CITY OF ALBUQUERQUE

PLANNING DEPARTMENT – Development Review Services

May 6, 2014

**RE: University Height, Lot 12-A Block 2
Grading and Drainage Plan
Engineer's Stamp Date 4-28-2014 (K16D032)**

LOT 12-A, BLOCK 2, UNIVERSITY HEIGHT ADDITION
GRADING AND DRAINAGE PLAN

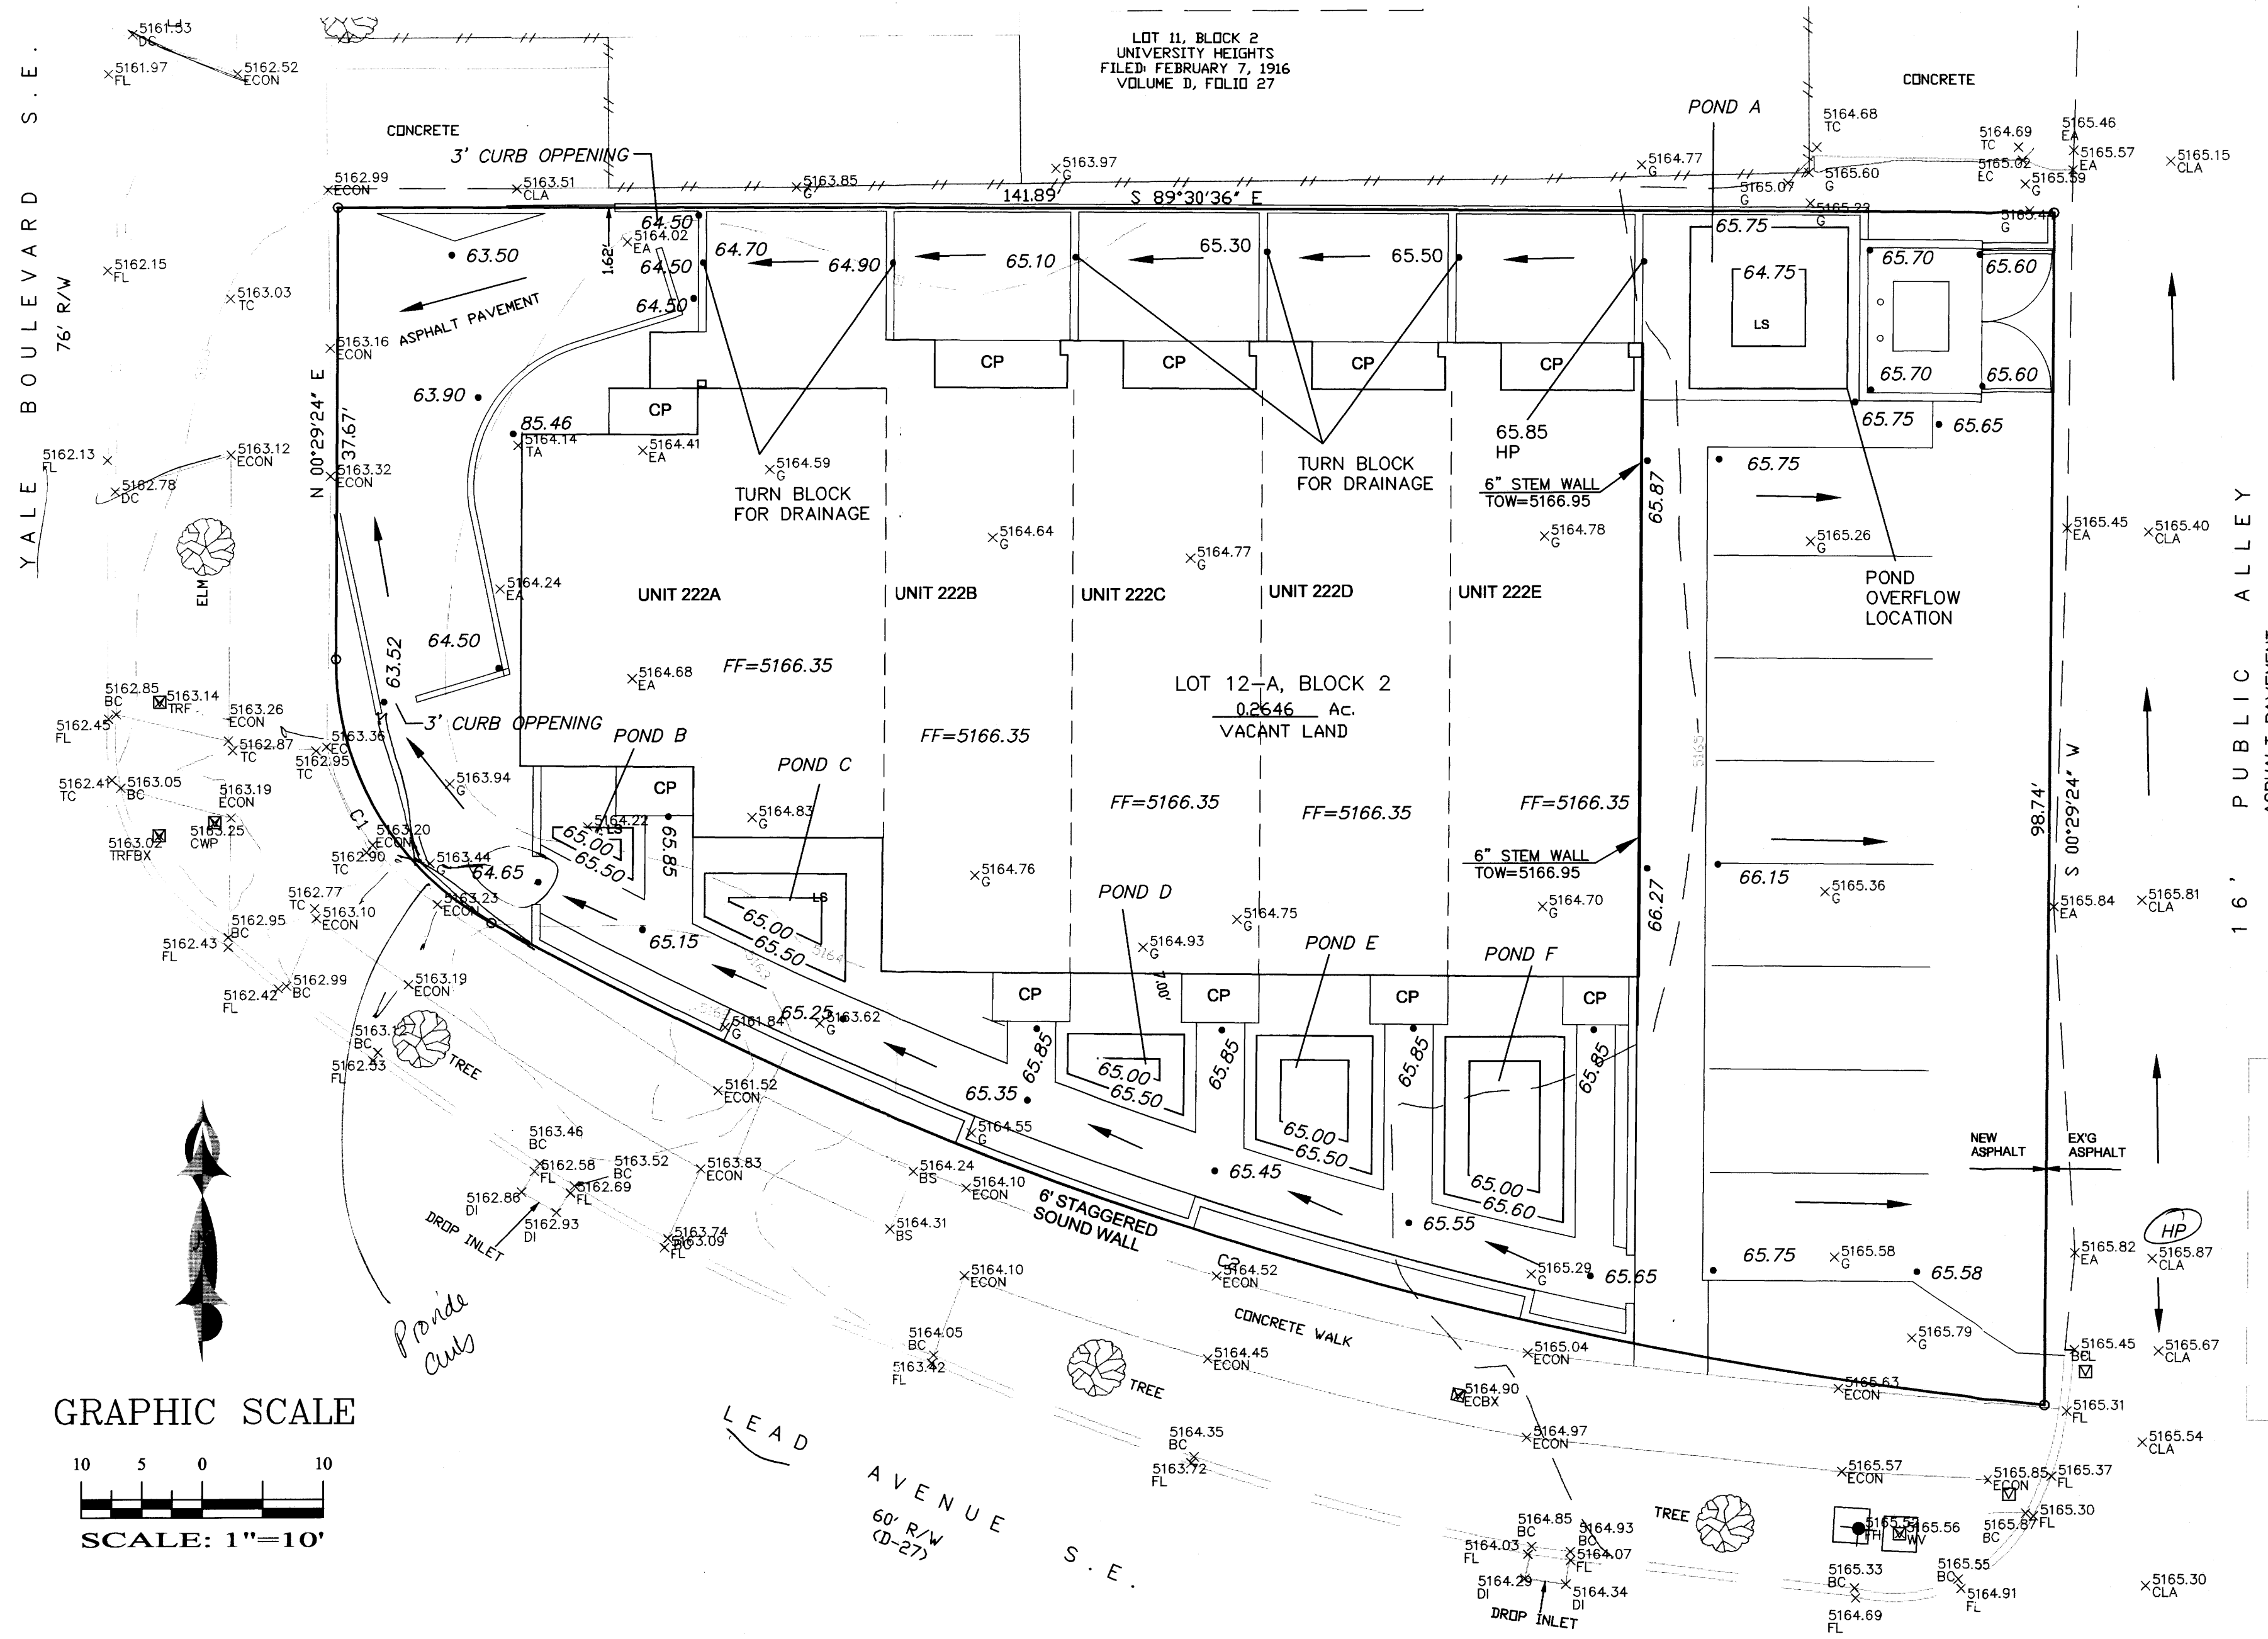
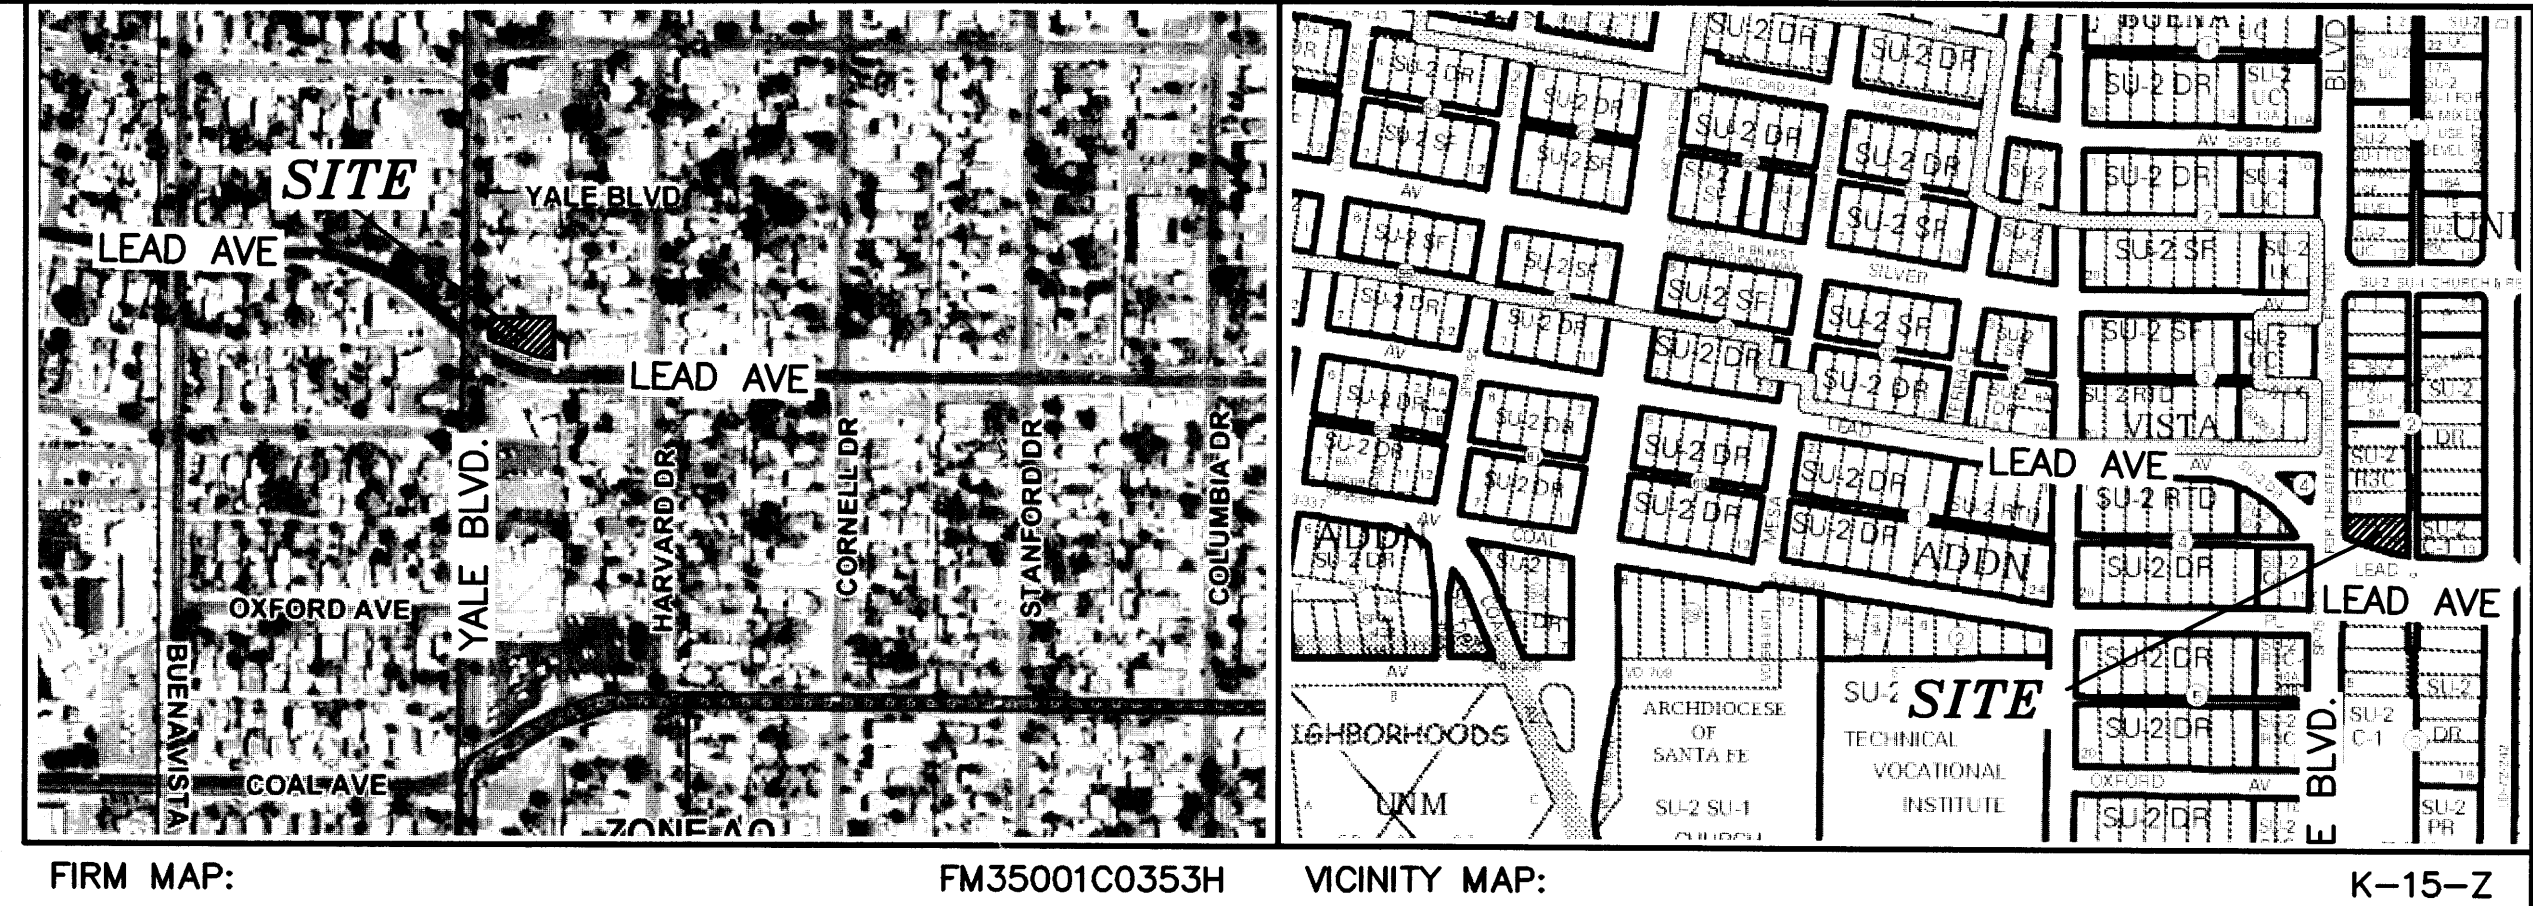
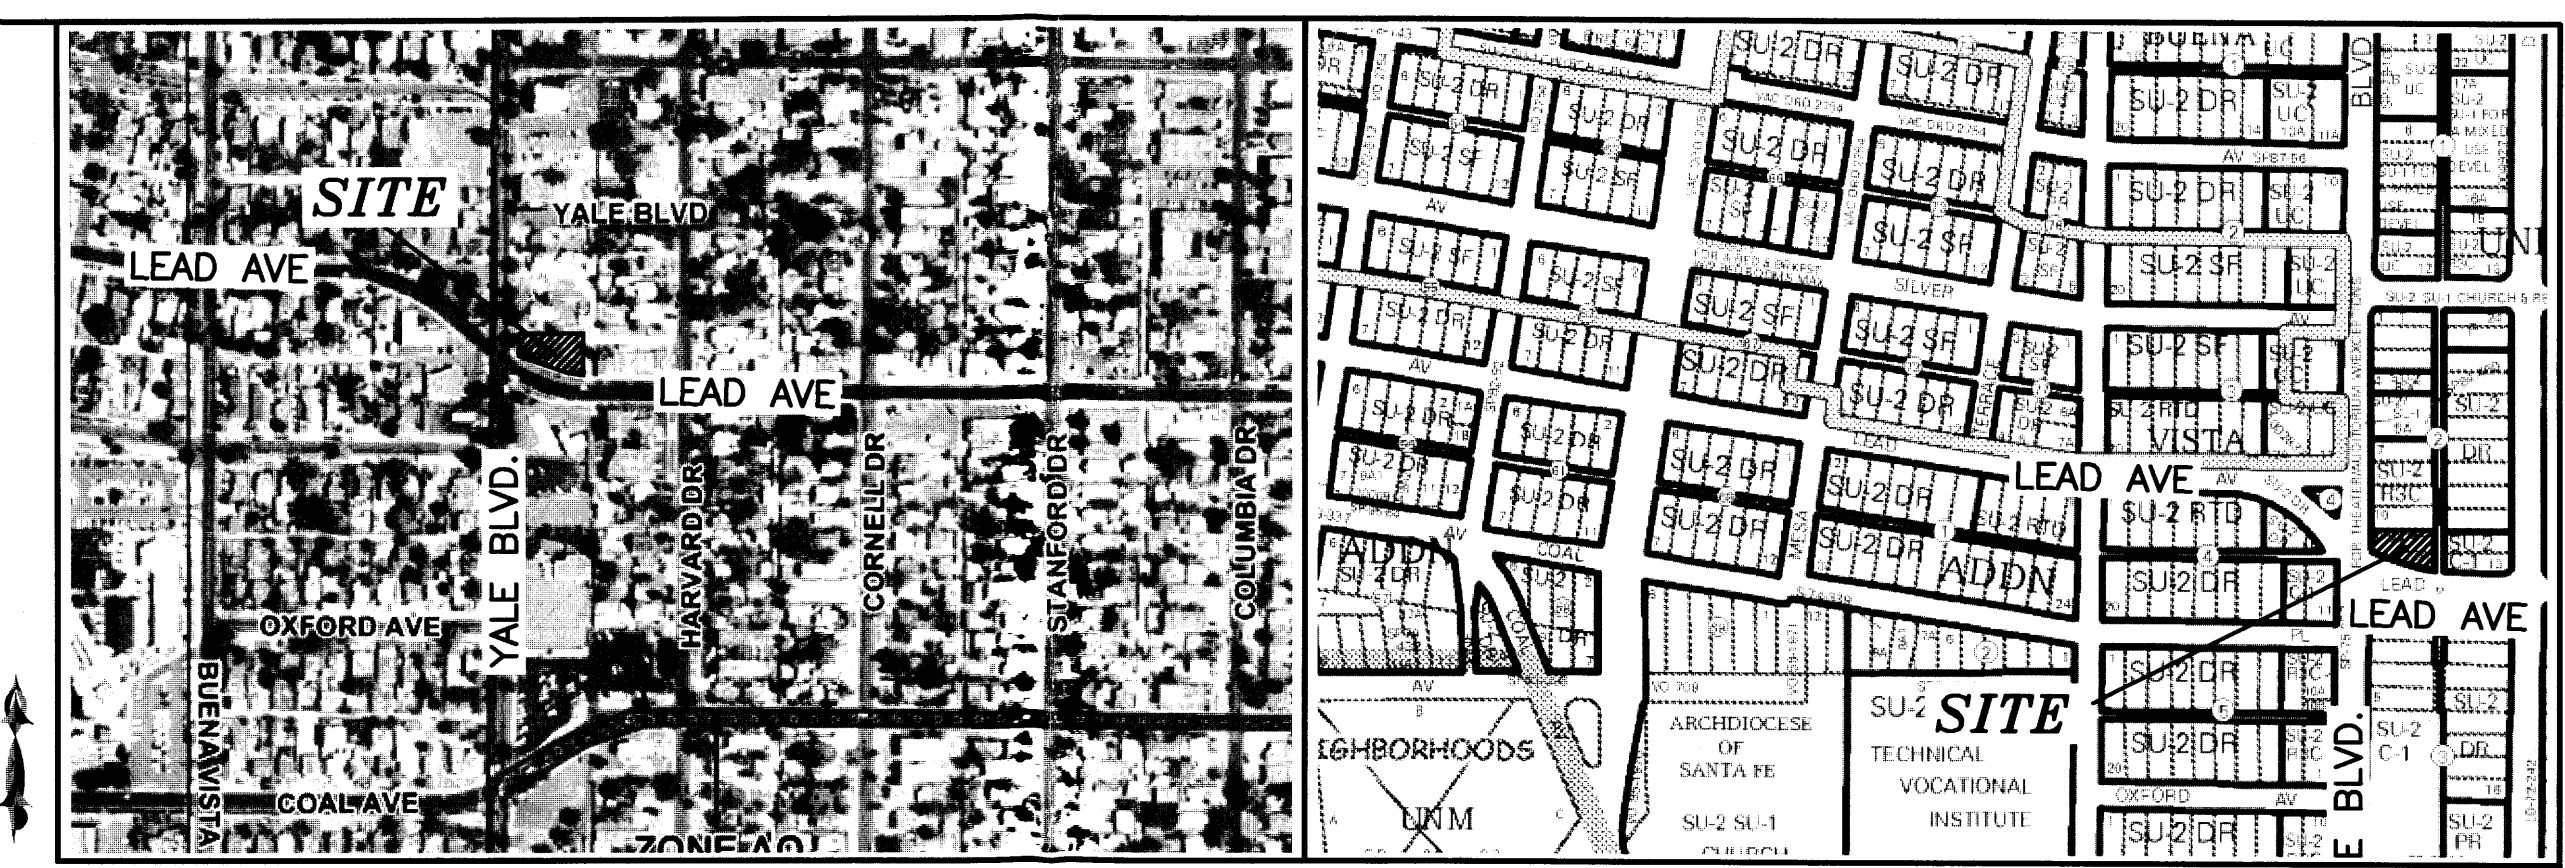
- It appears flows on southwest corner outfall to corner rather than thru drivepad. Provide berm, curb or similar to direct flow to outfall at drivepad and to support flow arrows.
